<u>DRB CASE ACTION LOG - BLUE SHEET</u>

Project #: 1004776	Application #: 12DRB - 703104
Project Name: Volcano Business	Park Phase
Agent: Brasher & Lorenz	Phone #:
Your request was approved on $1-2-13$ following departments - outstanding comments	by the DRB with delegation of signature(s) to the to be addressed
TRANSPORTATION:	
DABCWUA:	
CITY ENGINEER / AMAFCA:	
□ PARKS / CIP:	
□ PLANNING (Last to sign):	
PLATS: Planning must record this plat. Please su	bmit the following items:
-The original plat and a mylar copy for -Tax certificate from the County Treas -Recording fee (checks payable to the	surer.
with County Clerk.	be obtained prior to the recording of the plat
☐ AGIS DXF File approval required. ☐ Copy of recorded plat for Planning.	obtained prior to Planning Department's signature.
ALL SITE PLANS: 3 copies of the approved site plan. Include	all pages.

SUBJECT: Horizon Academy West

3021 Todos Santos Street NW Site Plan for Building Permit Project 1004776

SHEET TITLE: LANDSCAPE PLAN
PROJECT: HORIZON ACADEMY WEST ELEMENTARY CHARTER SCHOOL
3021 TODOS SANTOS STREET NORTHWEST ALBUQUERQUE, NEW MEXICO 87120

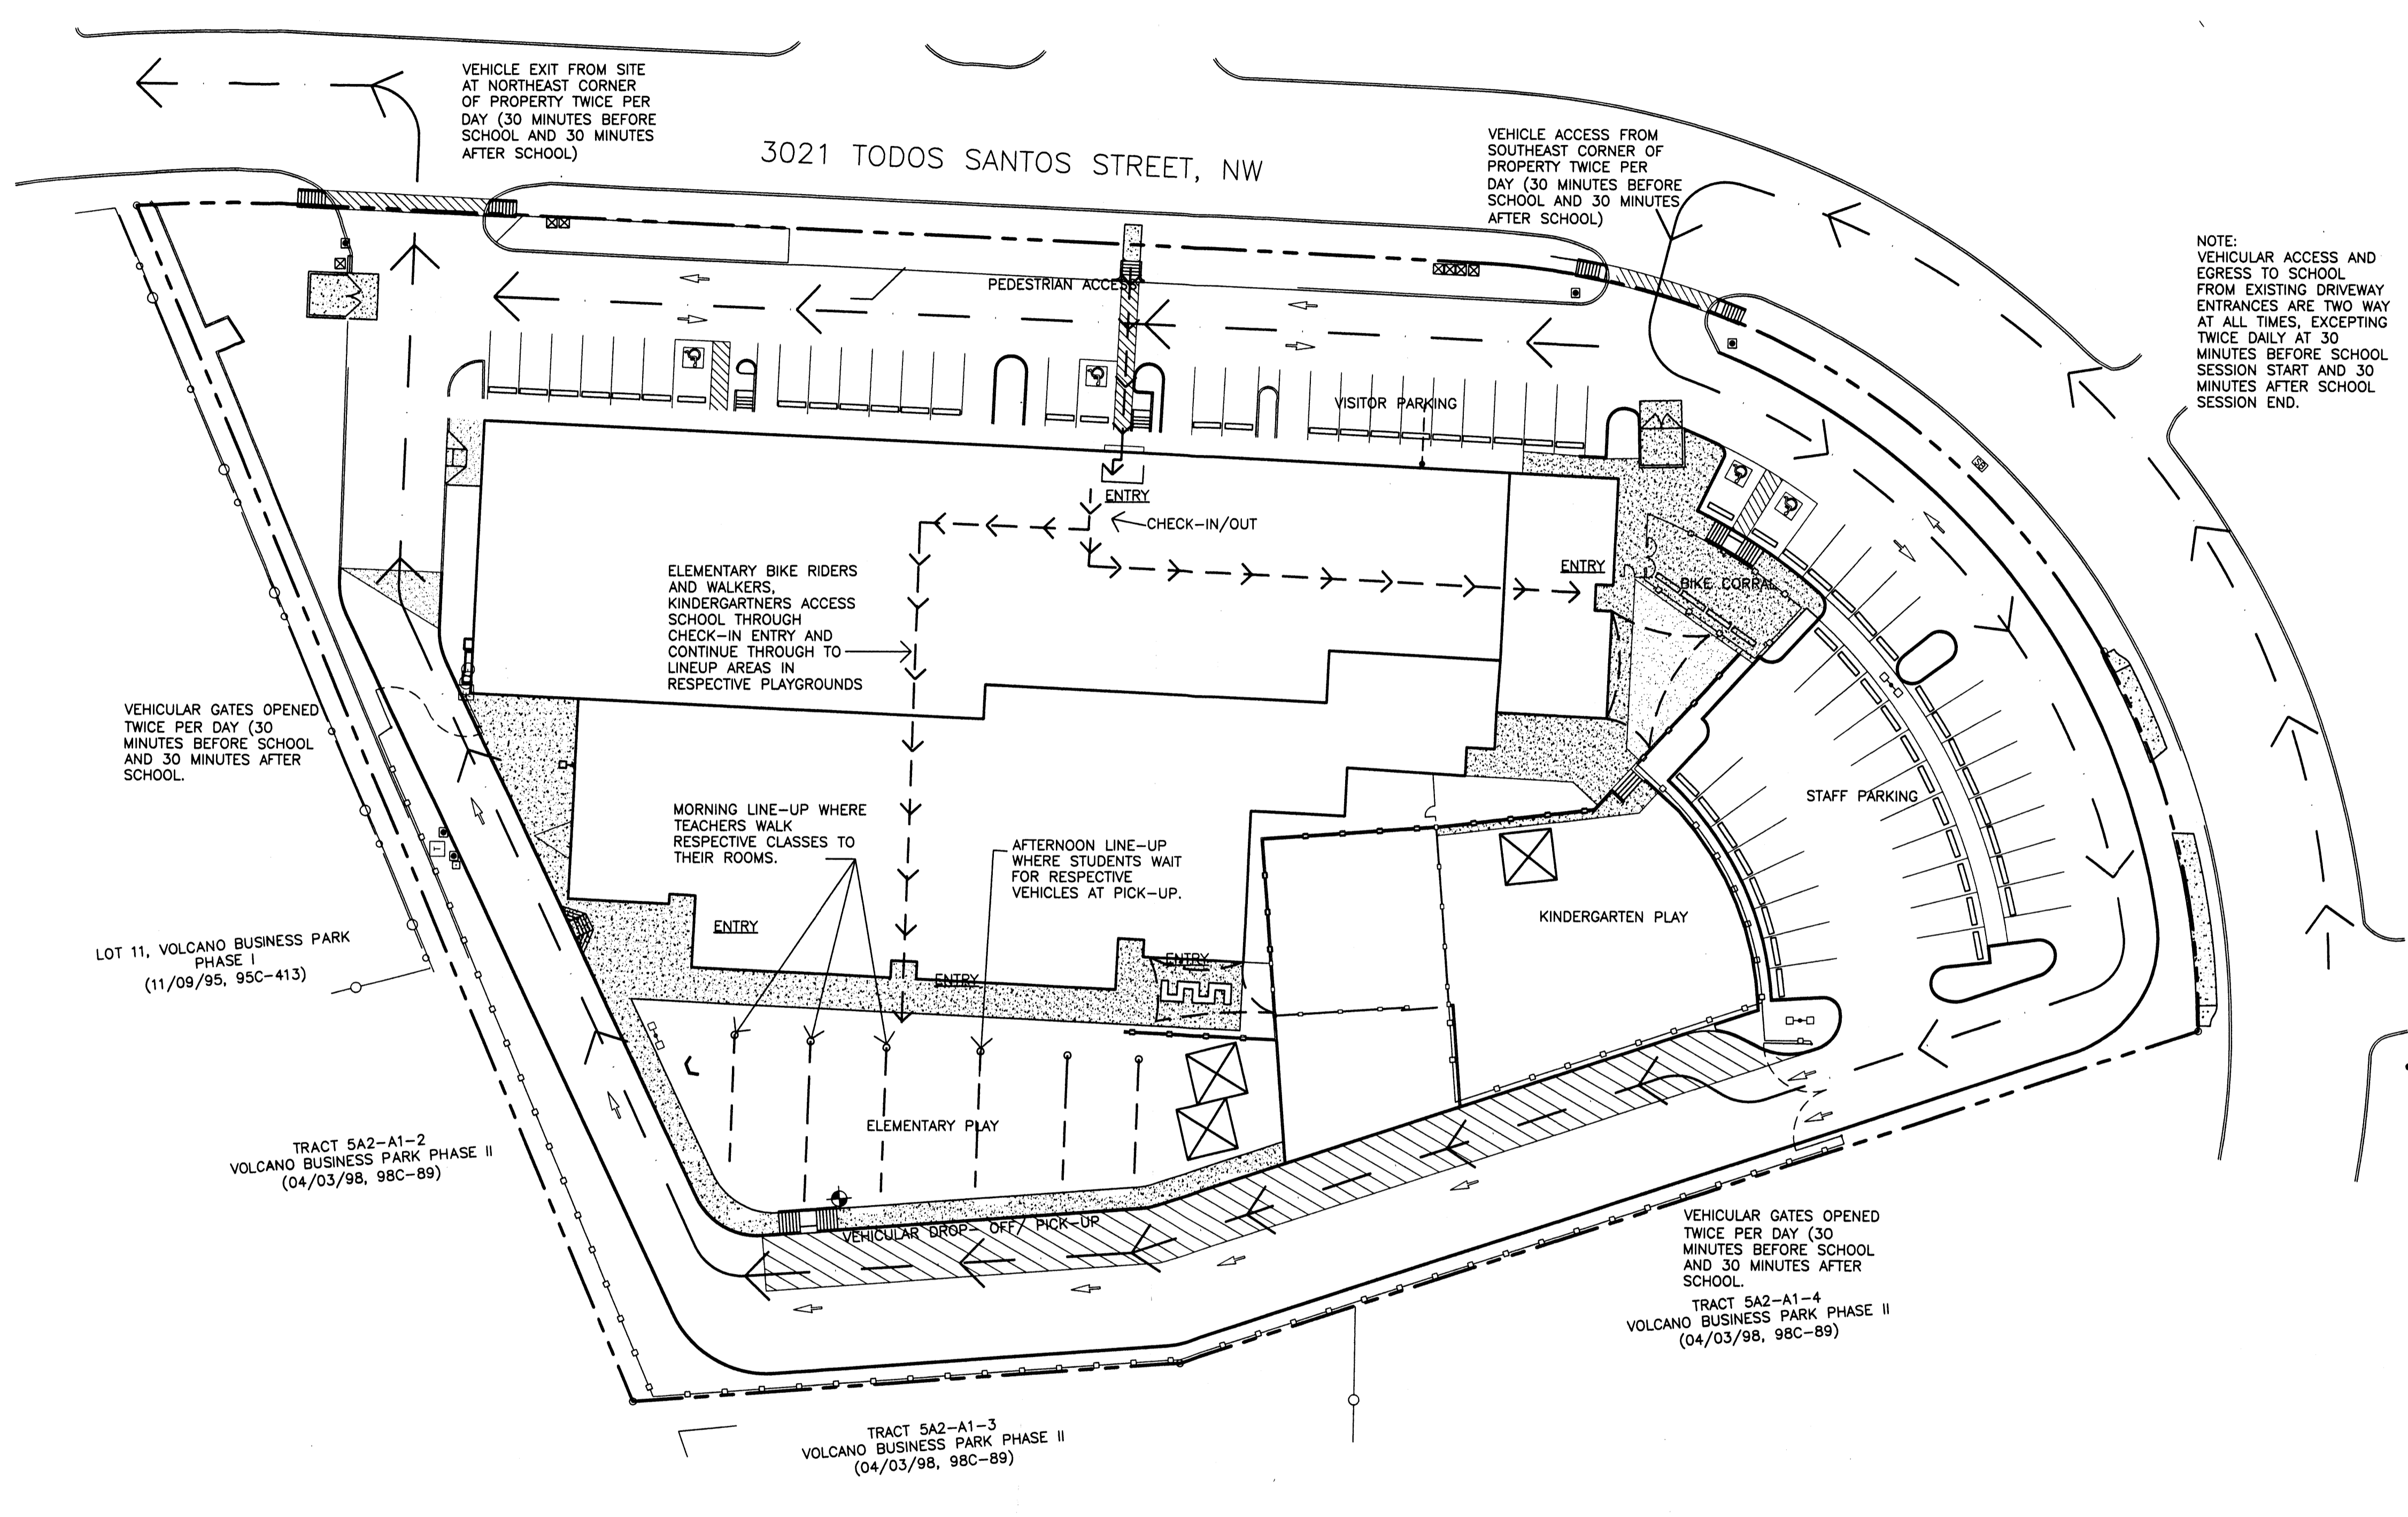
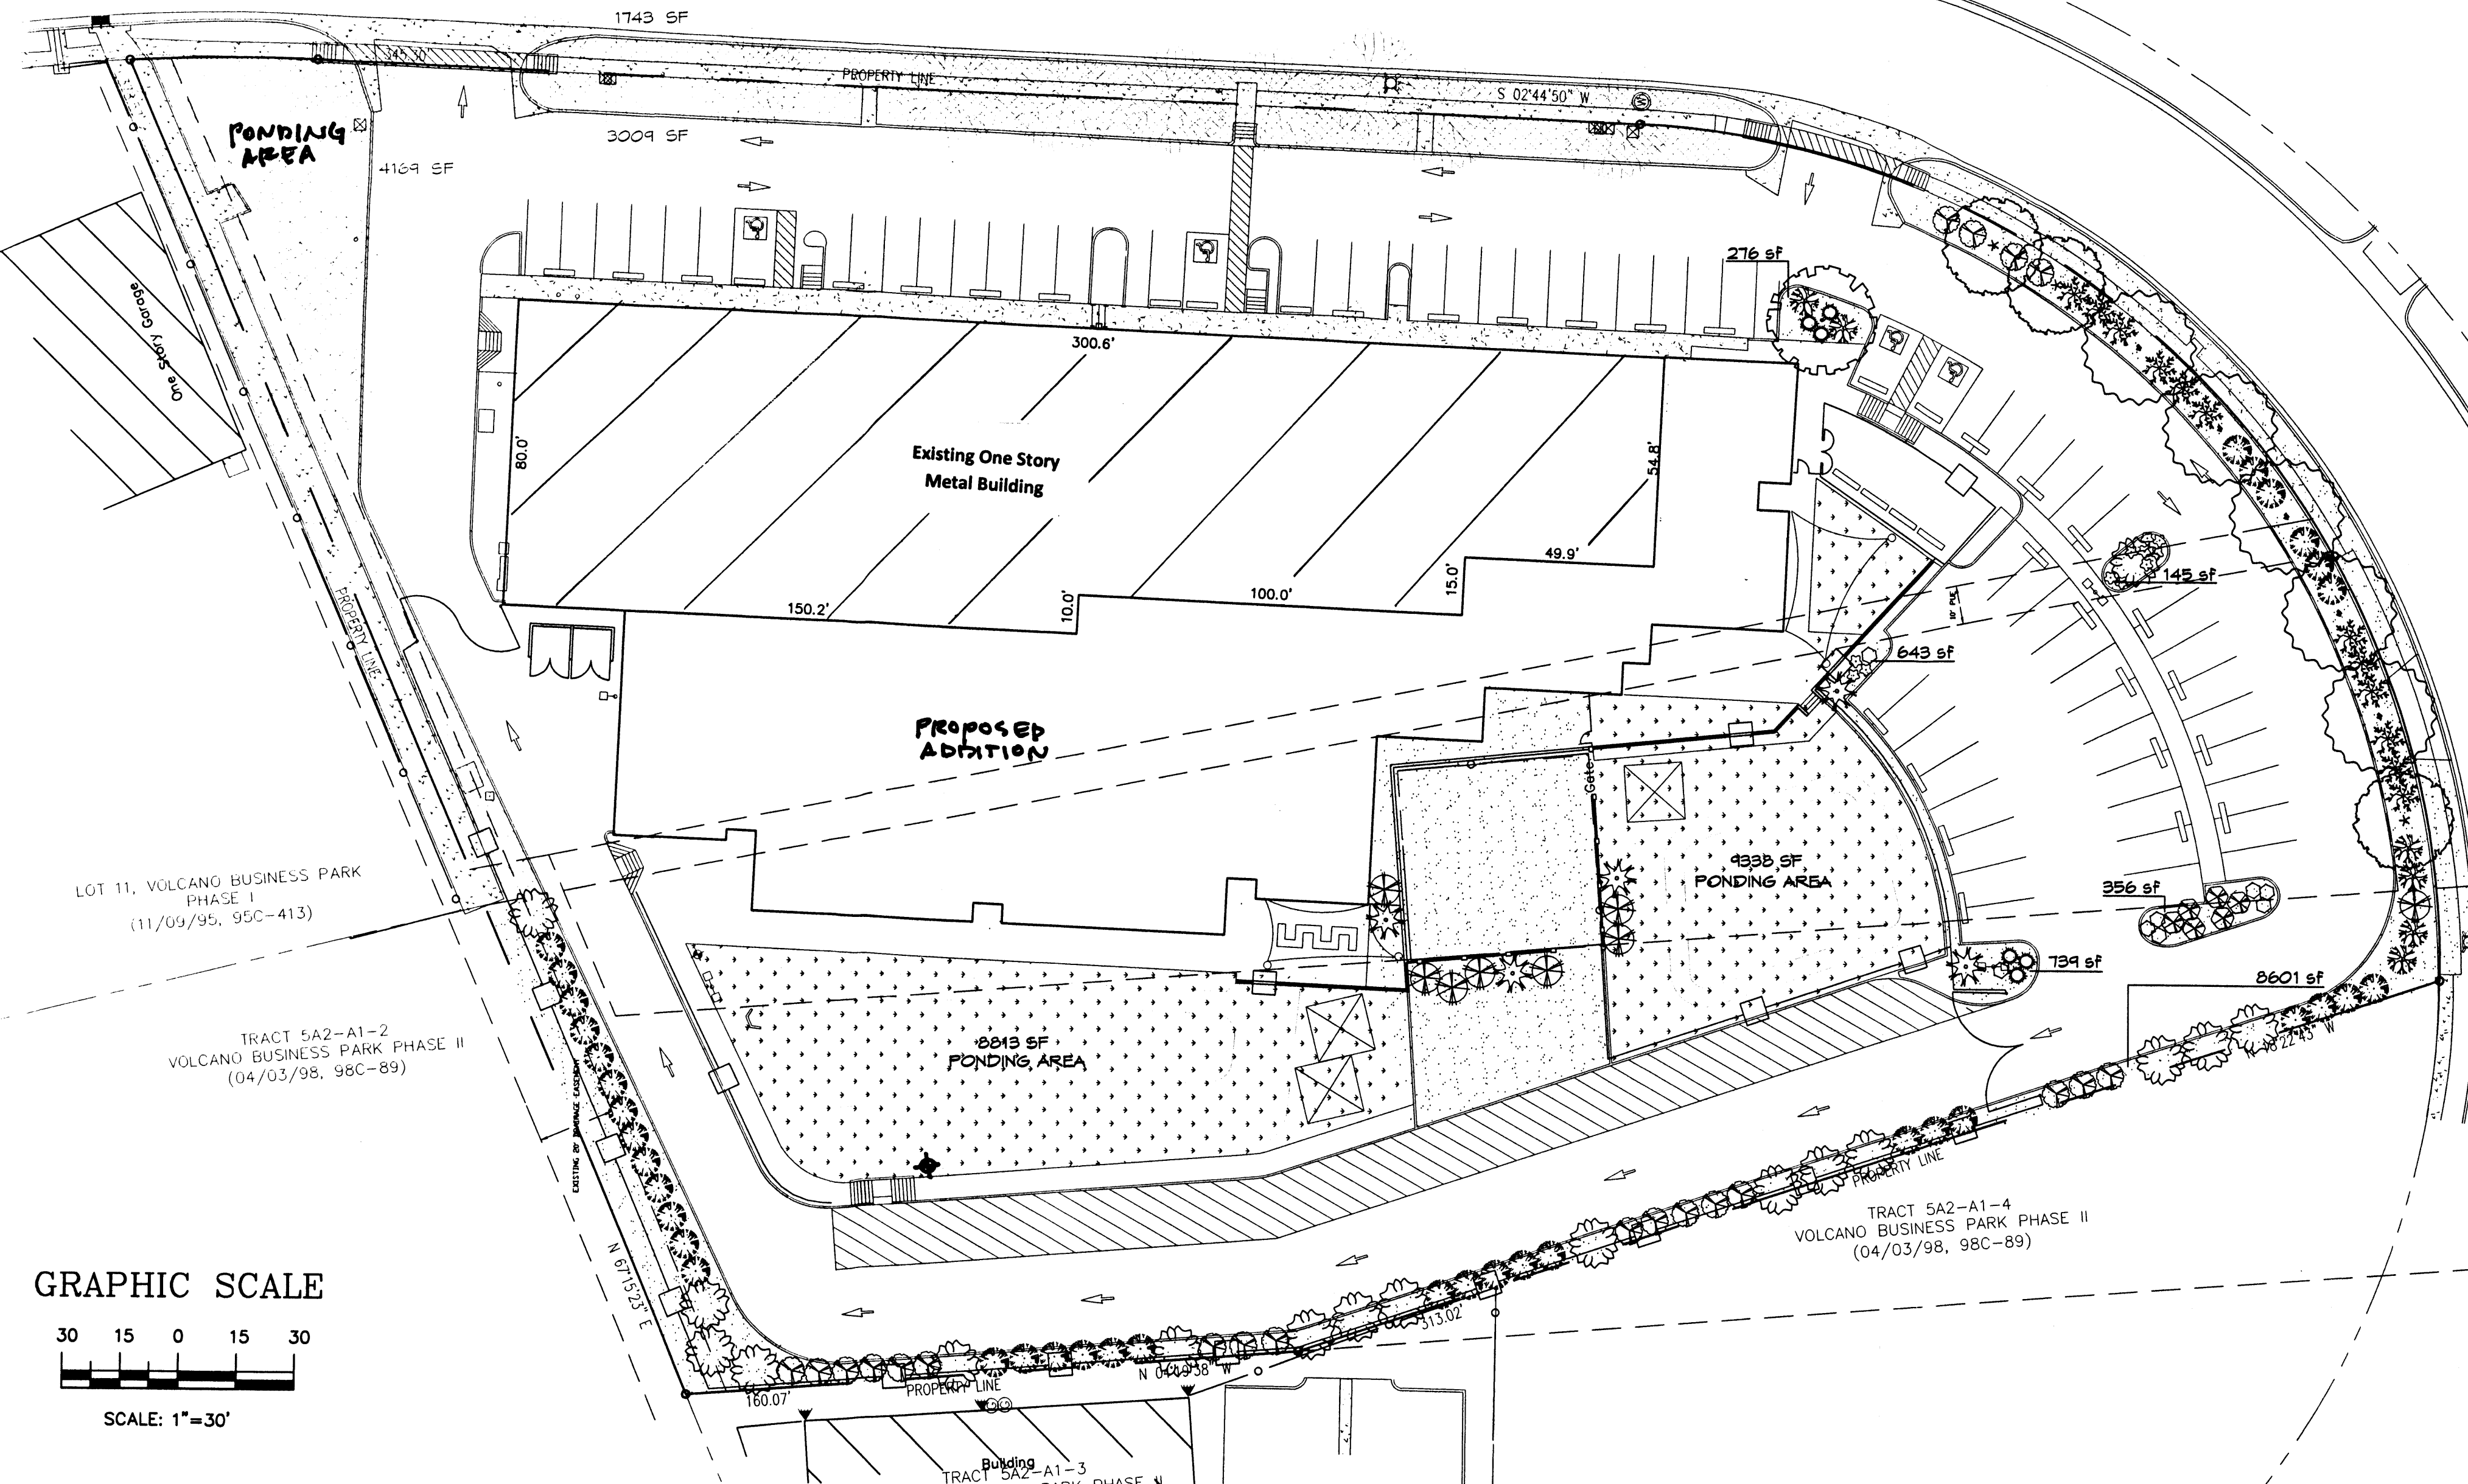
- b. Sheet L 1.0 has been revised to read "One Story Building"
 - c. The Landscape areas and percentages are provided.
 - d. Retention Pond labels have been changed to "Detention Pond" on all sheets.
